Submission No.			190	
Organisation Name or Name of Submitter			Michael A Doyle and Carmel Smith Doyle	
Item No.	Section Ref.	Page No.	Observation Statement	TII Response
Re: Metrolink Railway Order 2022, Estuary to Charlemont, Reference Number NA29N.314724				
1	Letter	1	<p>I live at 34 Dartmouth Road.....</p> <p>Firstly, in general, I am in favour of the broad aim of the Metrolink project to connect Dublin’s city centre to our national airport.</p> <p>However, as a resident living in the Dartmouth/Charlemont area, I wish to set out a number of observations, for the Board’s consideration, regarding the proposal to locate the Terminus station at Charlemont-Dartmouth.</p> <p>My family home is in the midst of the community where the Terminus station at Charlemont is proposed to be located, and is dangerously close to the proposed very deep pile insertions and deep station box excavations.</p> <p>I would request that An Bord Pleanála give very serious considerations to the important issues raised in this submission, and, in consequence, mandate Planning Conditions appropriate to the nuisance value inherent in this application for a major transport hub located in a heretofore quiet Victo

CHARLEMONT STATION

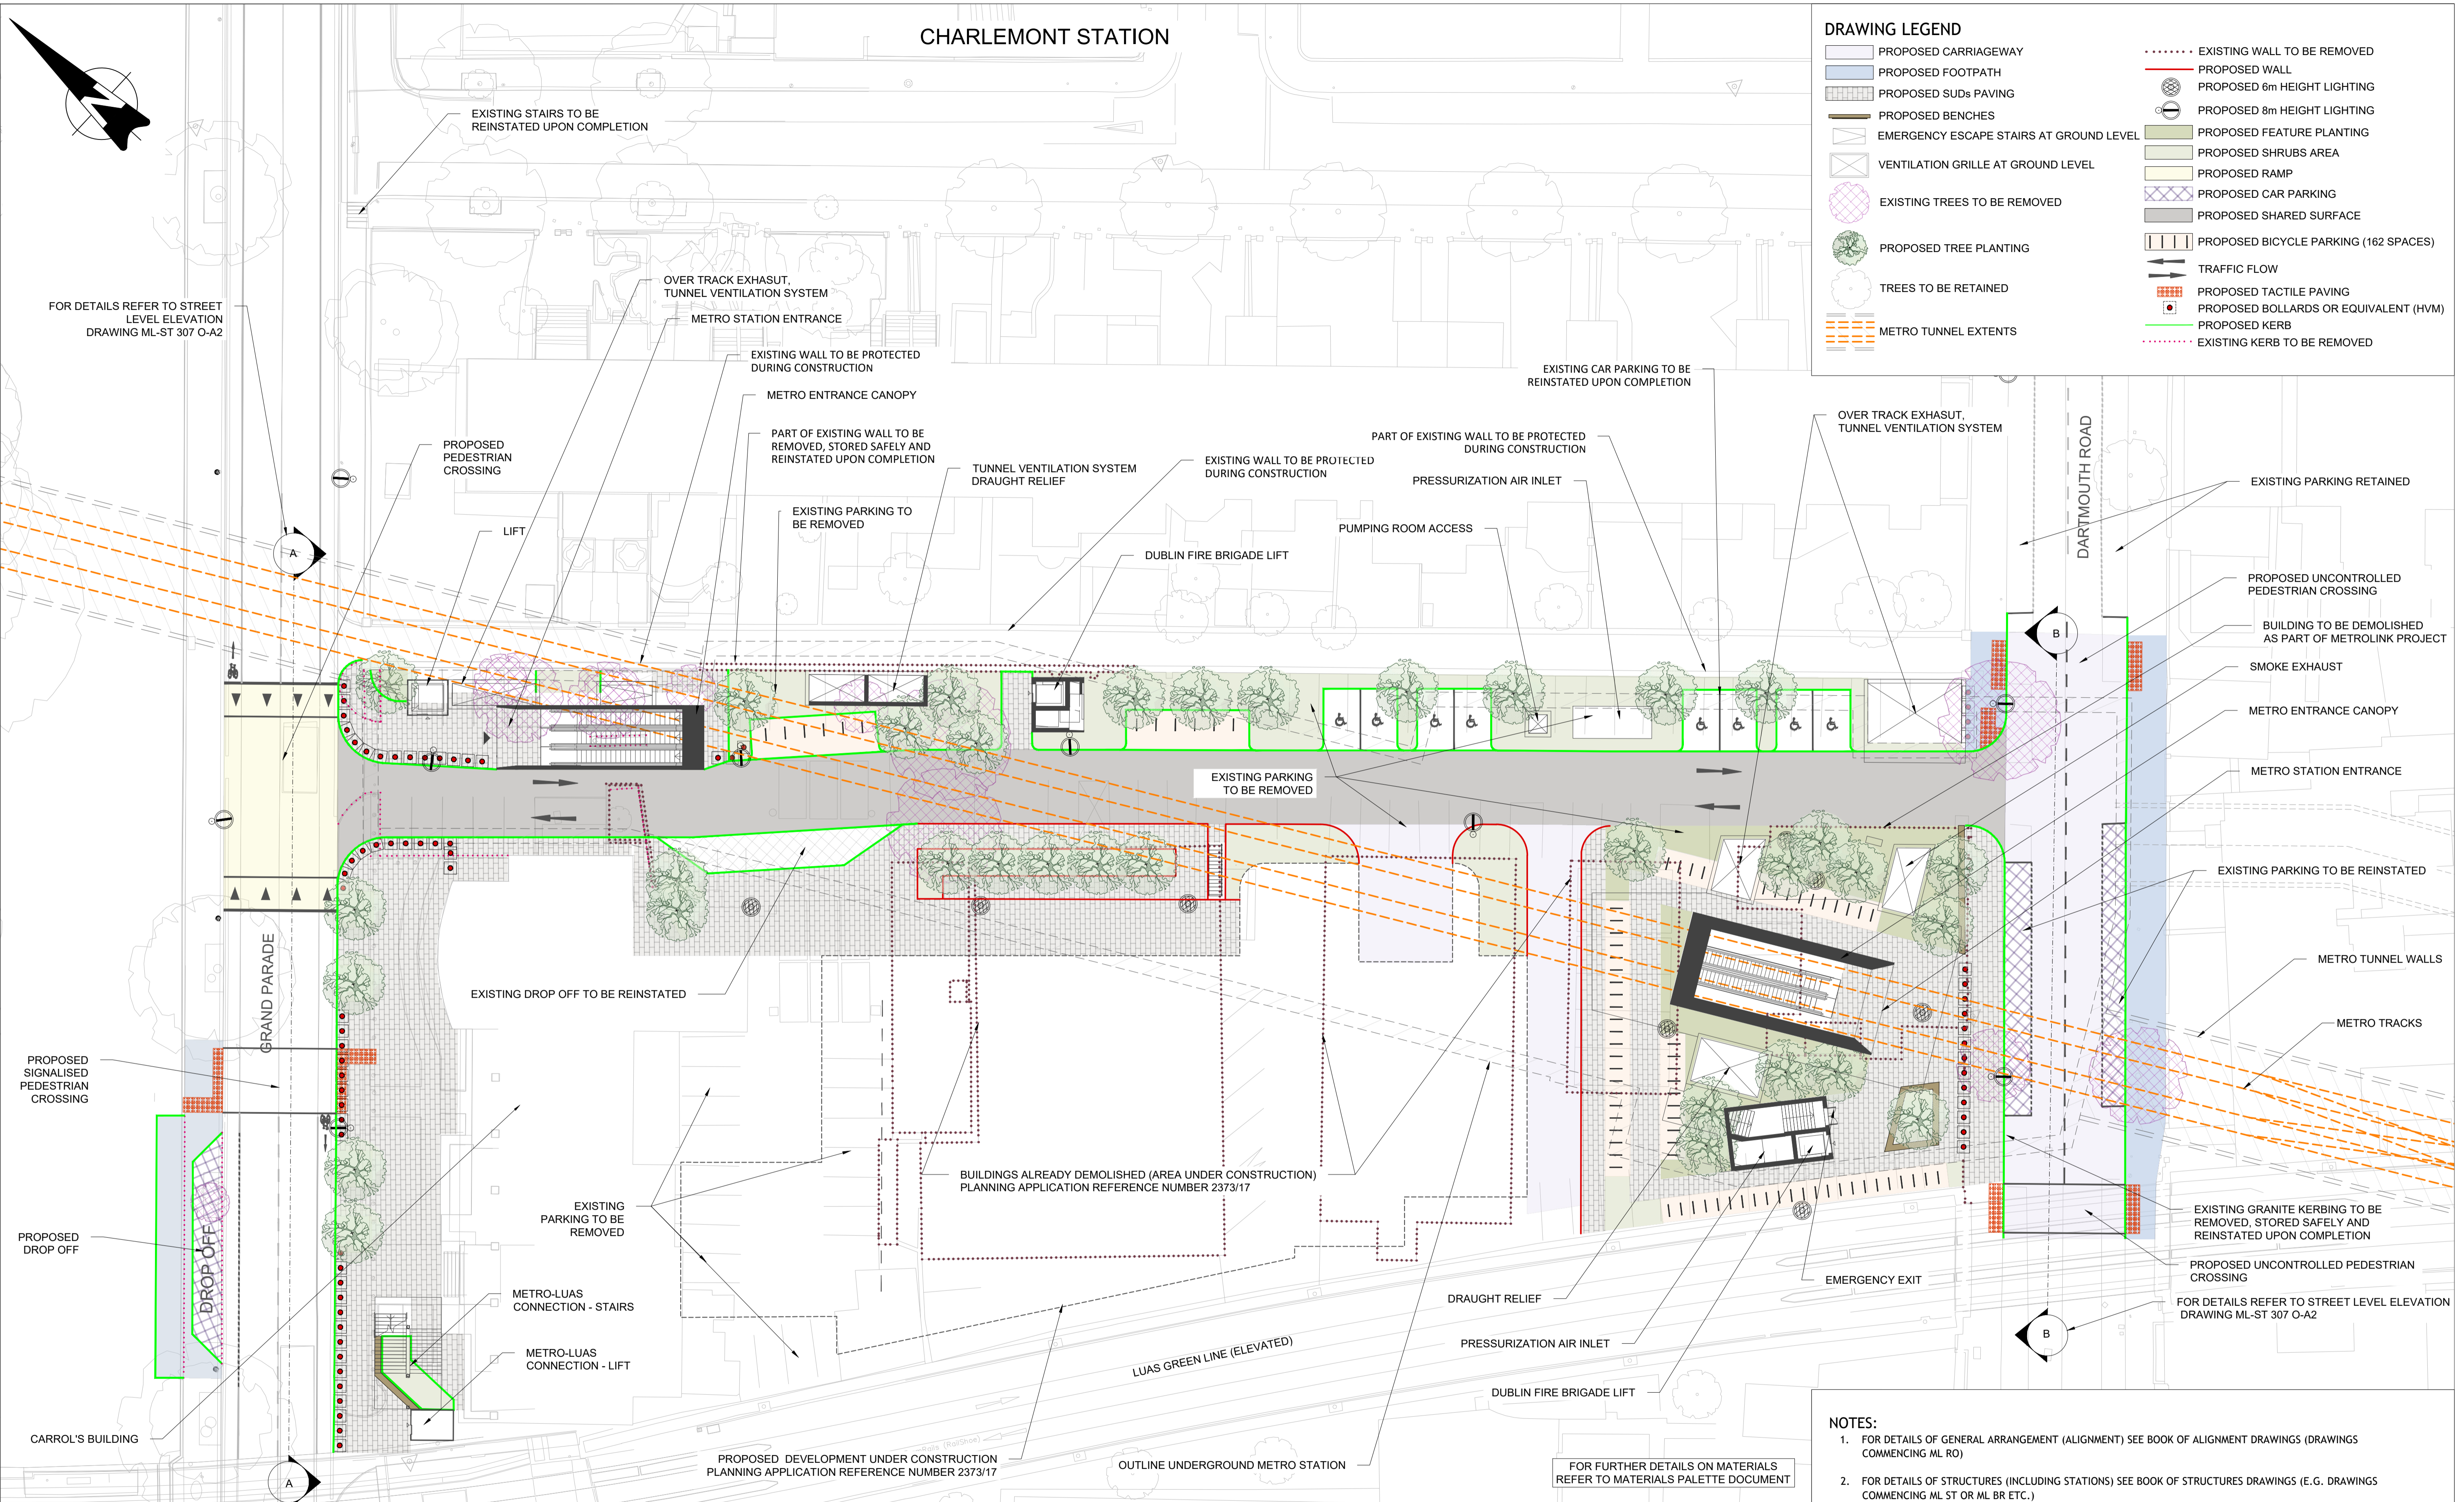
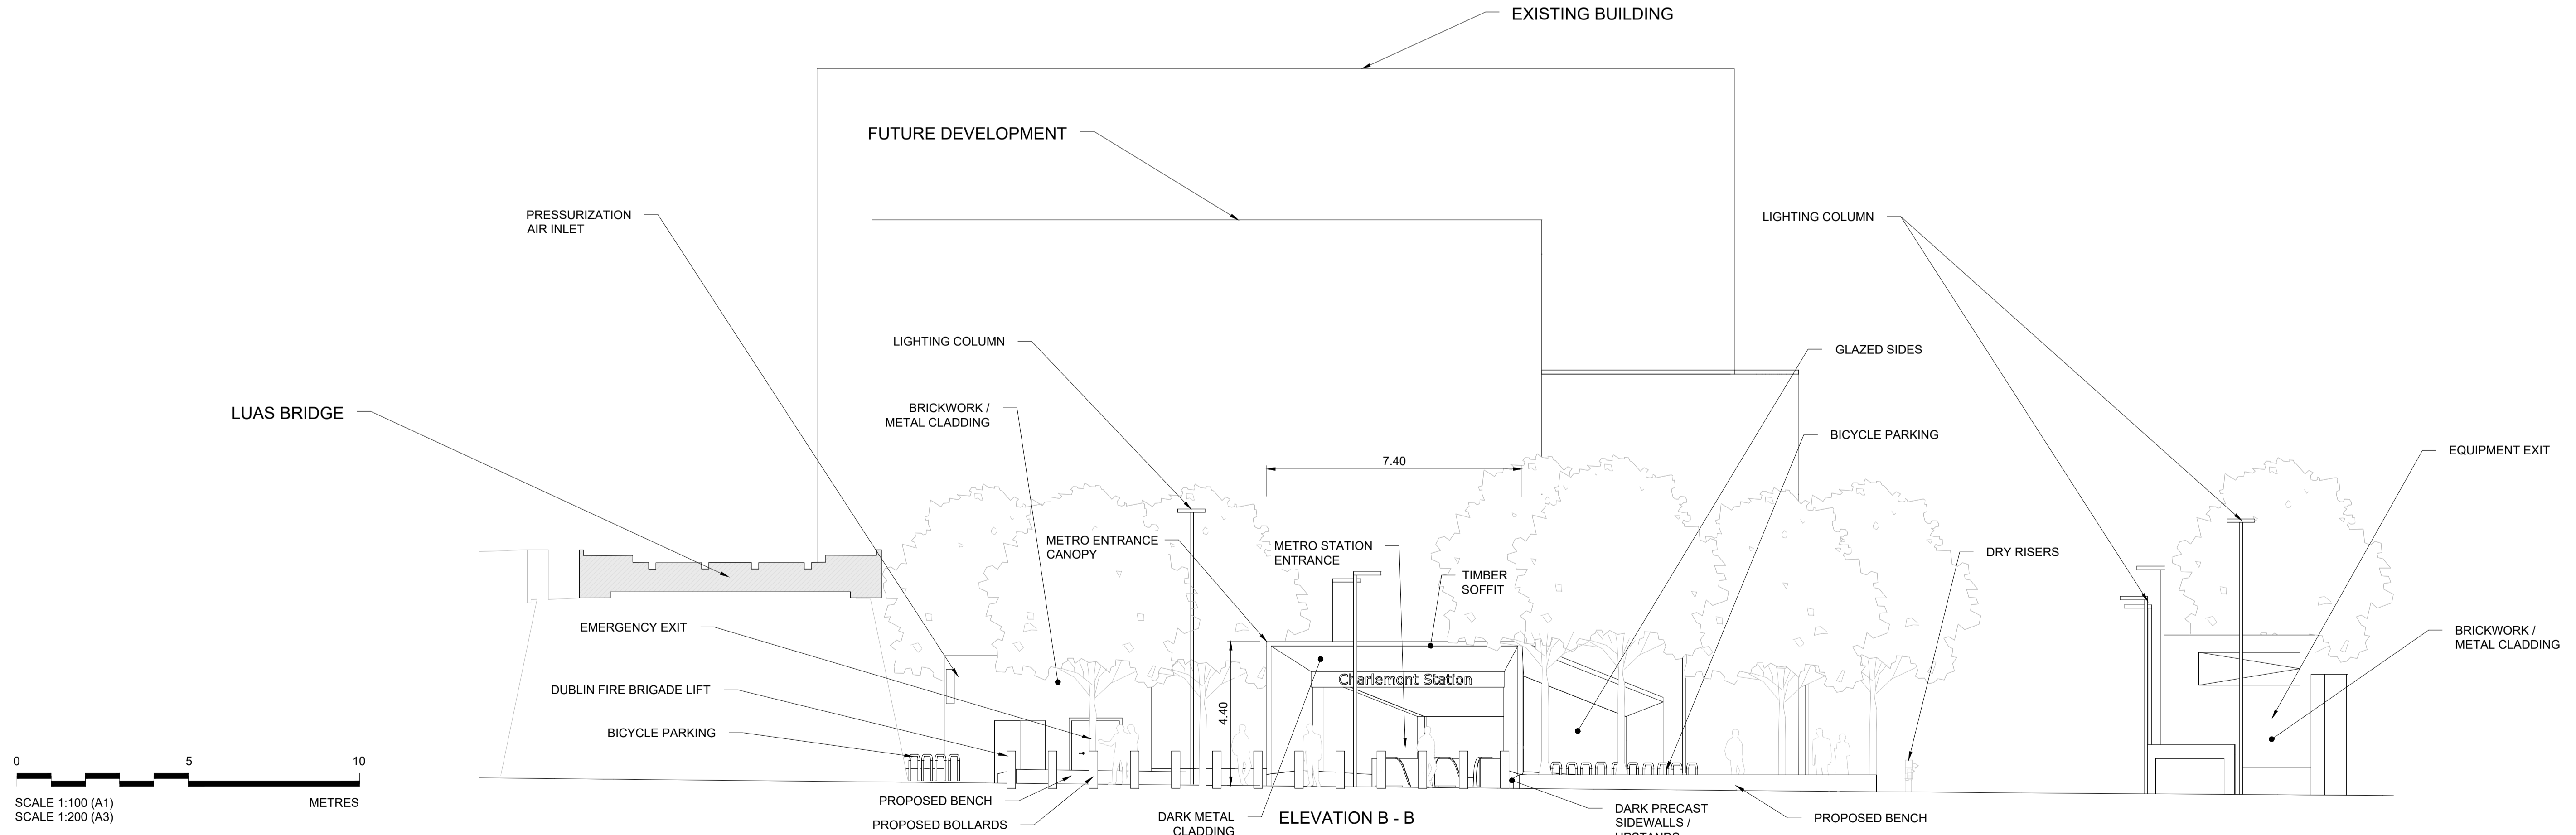
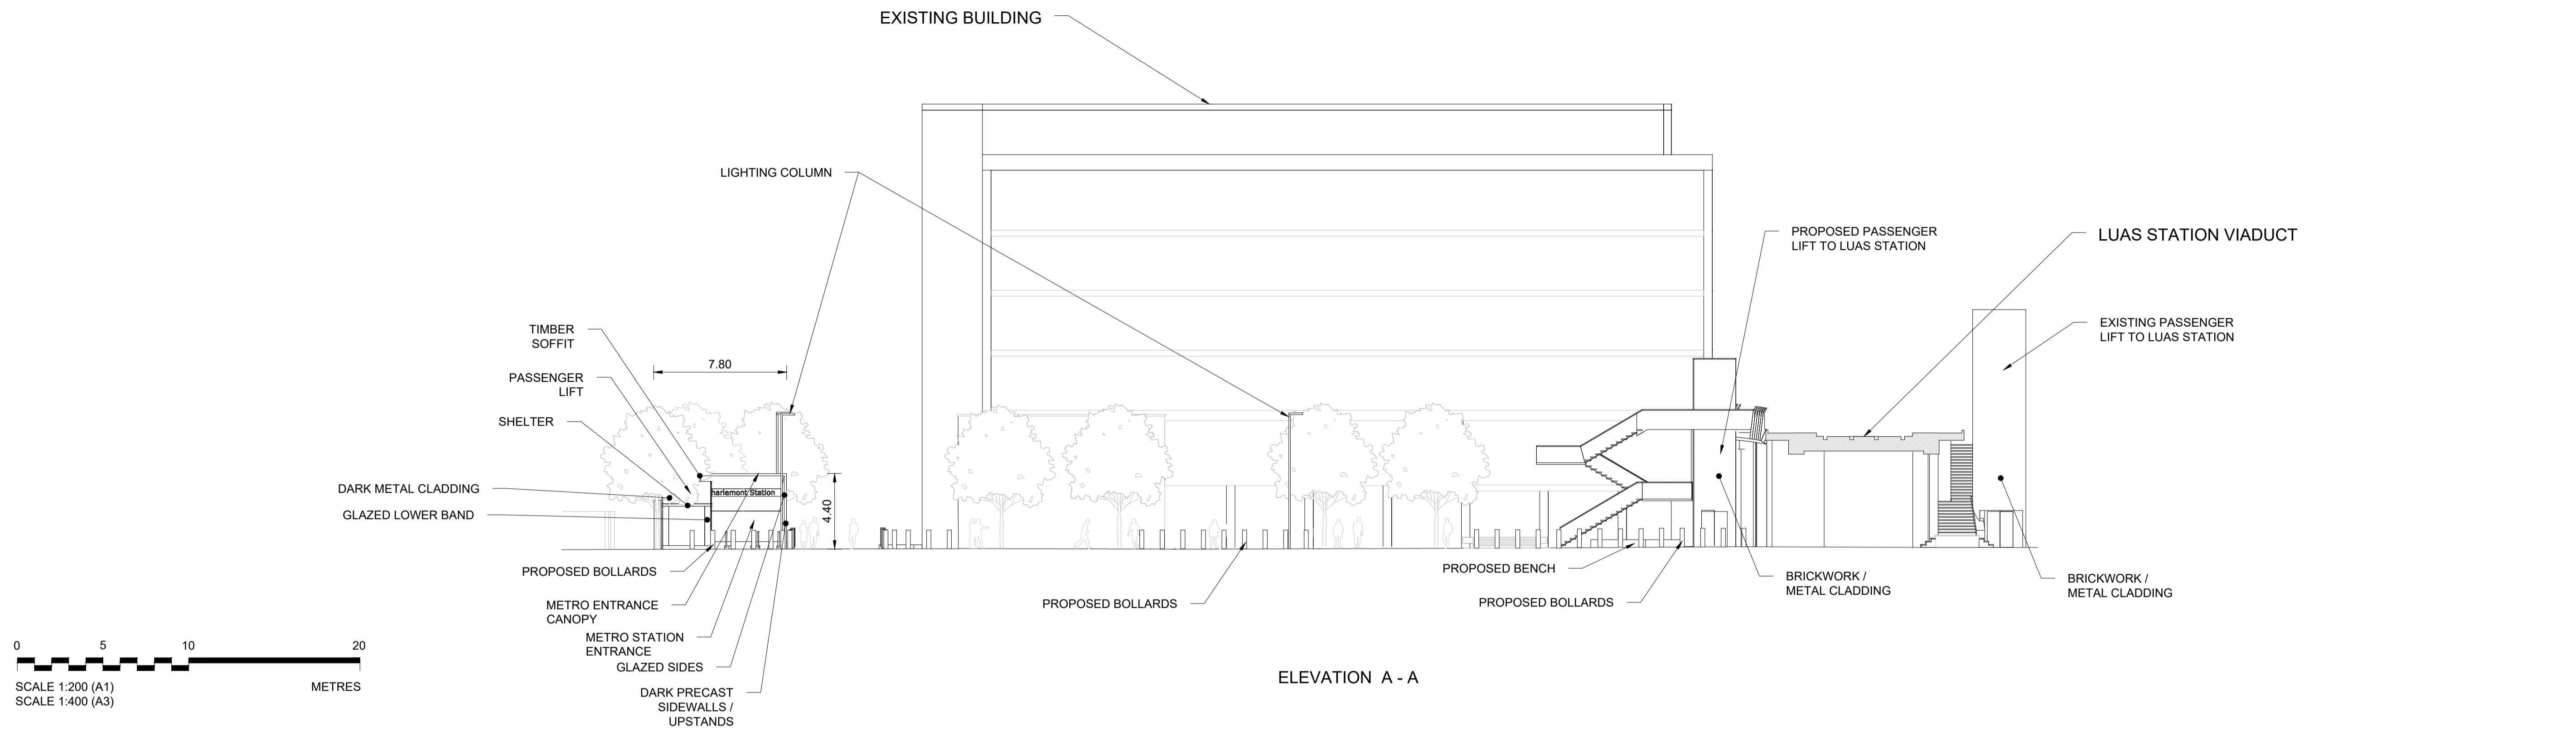
6	SETTLEMENT, SUMMARY	6	<p>1.1 ACCURACY OF DEPICTION OF BORED PILES ON DARTMOUTH ROAD, Drawings do not accurately reflect actual position of bored piles.</p>	<p>The drawings do depicted the location of the station structure in relation to Dartmouth Road. Please refer to the submitted Railway Order drawings, Structures Details, Book 2 of 3, drawing ML1-JAI-SRD-ROUT_XX-DR-Z-02090, which indicates the outline of the station external walls (Diaphragm Wall piles) in relation to the properties along Dartmouth Road.. The EIAR Chapter 5, MetroLink Construction Phase, Section 5.10.13 and Appendix A5.3 Section 8.14, also indicates the position of the station wall and explains the proposed construction of Charlemont Station.</p> <p>Further information of the depth of the proposed station structure is provided on station floor level structural plan drawings ML1-JAI-SRD-ROUT_XX-DR-Z-02092 to 02095 together with associated longitudinal section Drawings ML1-JAI-SRD-ROUT_XX-DR-Z-02096.</p>
